CITY OF PORTLAND, MAINE
PLANNING BOARD

July 23, 2003

RE: Portland Sports Center, 512 Warren Avenue
Job ID #2003-0066, ID #278-B-001

On July 22, 2003, the Portland Planning Board voted unanimously 4-0 (Malone abstained, Lowry, Patterson absent) to approve the site plan for the Portland Sports Center. The approval was granted for the project with the following conditions:

FIELD BOOK #	DESIGN: PBB	PROJECT:
FIELD BOOK PAGE	DRAWN: PBB	PORTLAND SPORTS CENTER
FLAT FILE INDEX NUMBER	CHKD: WSD	512 WARREN AVENUE, PORTLAND, MAINE
PROJECT DIR.	DATE: APRIL 2003	LAYOUT & UTILITY PLAN
DRAWING NAME	SCALE: 1" = 40'	PROJ. NO. 03-213-00
		DWG. NO. 2 OF 7
		REV. 3

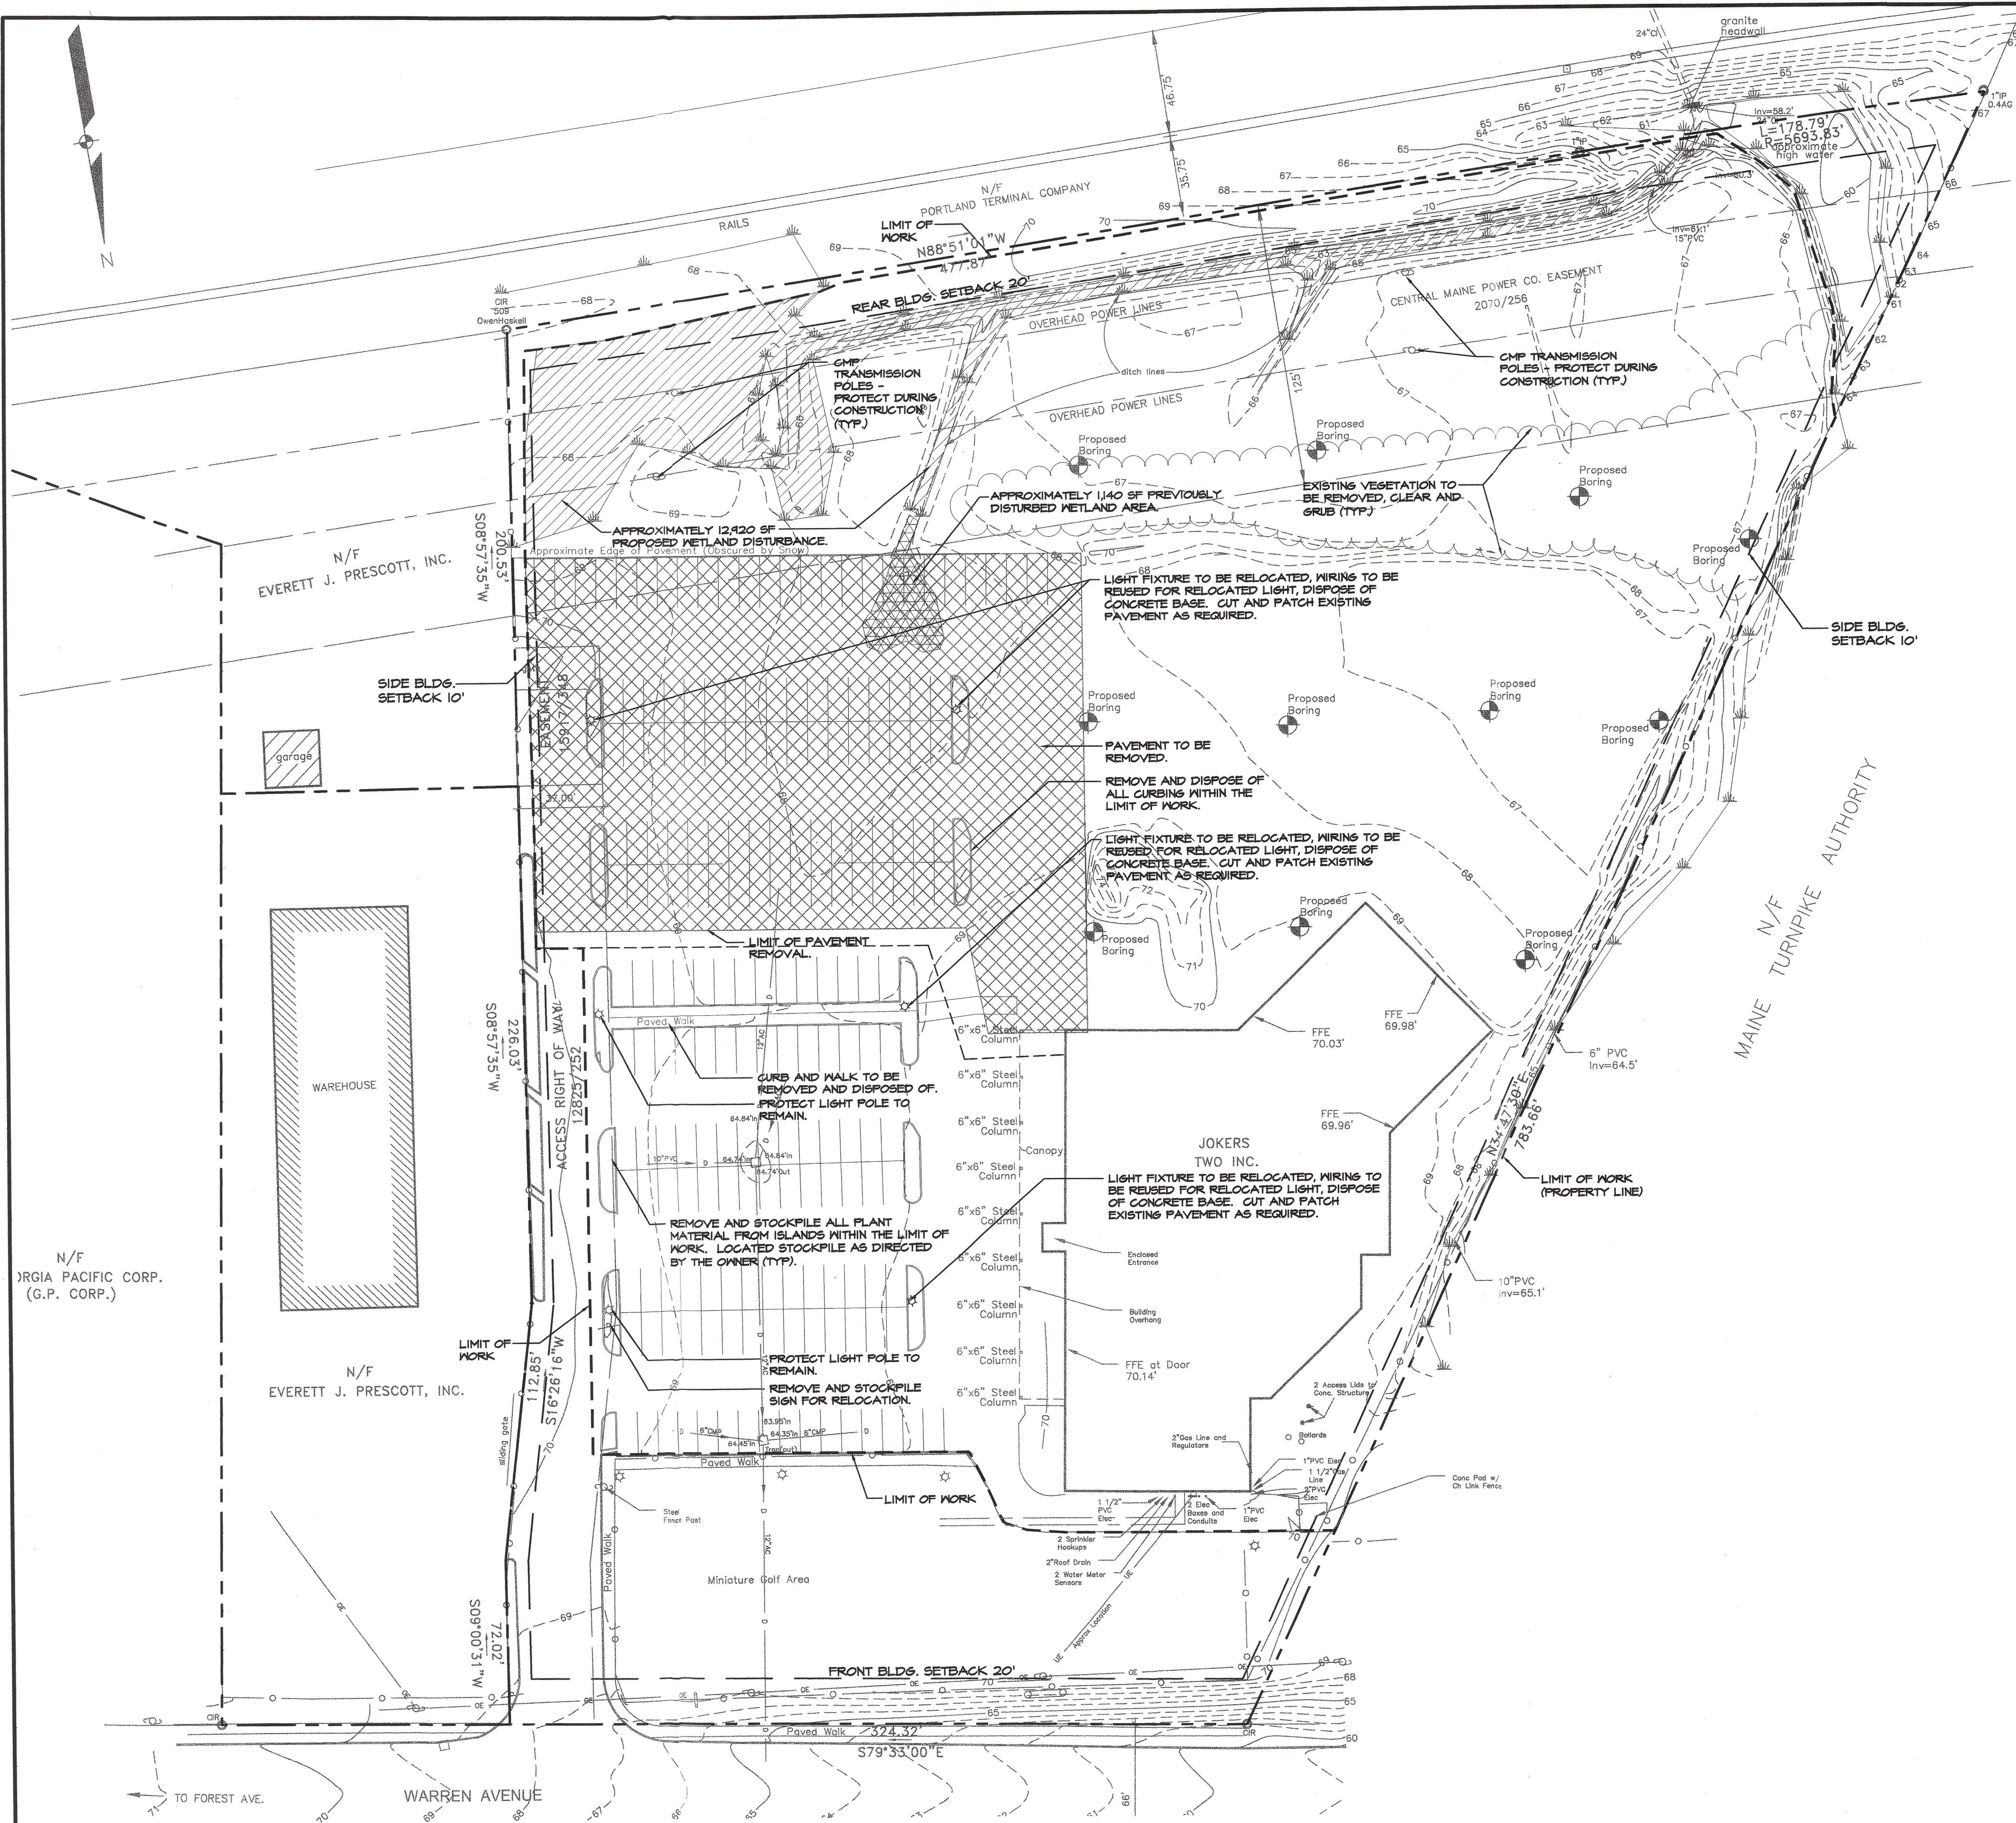
- iv. Fixture "E", as shown on the lighting photometric plan, shall not exceed 250 watts.
- v. that the applicant submit an executed Declaration of Portland Sports Center Condominium to staff prior to issuance of a building permit.

FIELD BOOK #	DESIGN: PBB	PROJECT:
FIELD BOOK PAGE	DRAWN: PBB	PORTLAND SPORTS CENTER 512 WARREN AVENUE, PORTLAND, MAINE
FLAT FILE INDEX NUMBER	CHKD: WSD	LANDSCAPE PLAN
PROJECT DIR.	DATE: APRIL 2003	PROJ. NO. 03-213-00
DRAWING NAME	SCALE: 1" = 40'	DWG. NO. 4 OF 7
		REV. 3

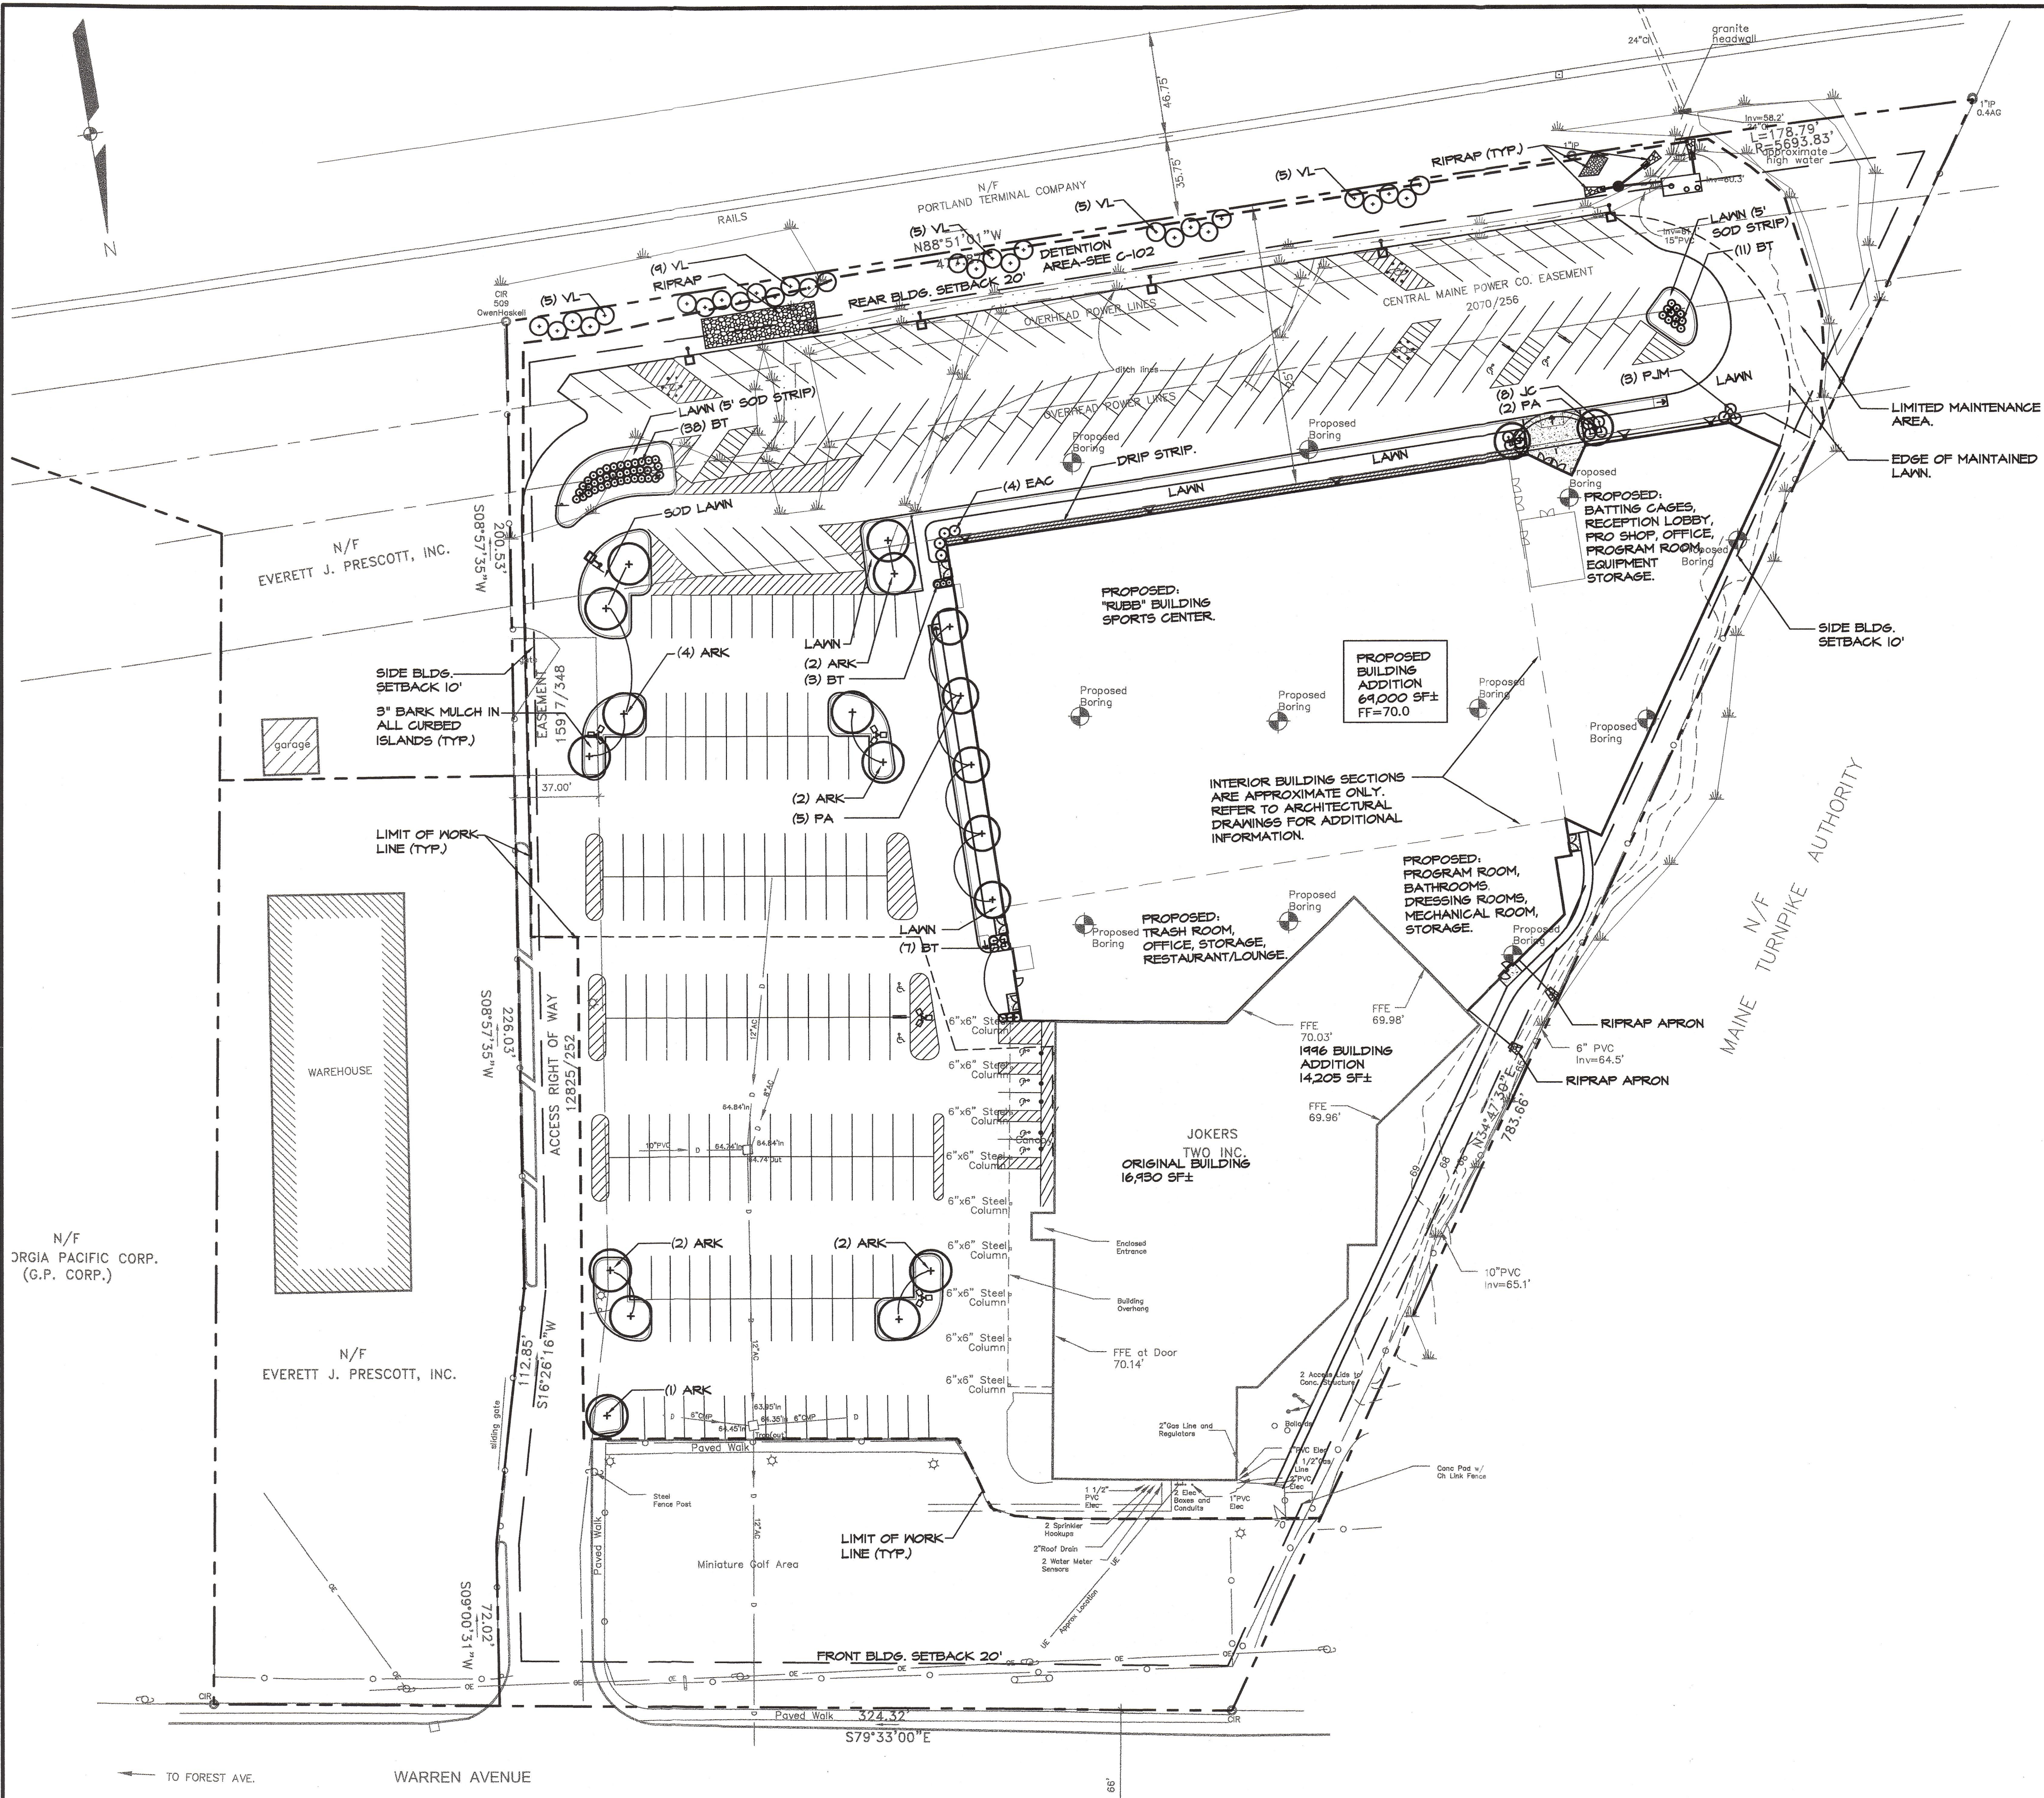
- ii. that the plans be revised to include a landscaped island with trees on the easterly side of the rear parking area, that groups of buffering be installed to screen the property from the rear, that the Crimson Barberry specie be changed to a Bayberry specie or a plant which is more natural and less invasive, and that the plan be reviewed and approved by the City Arborist.
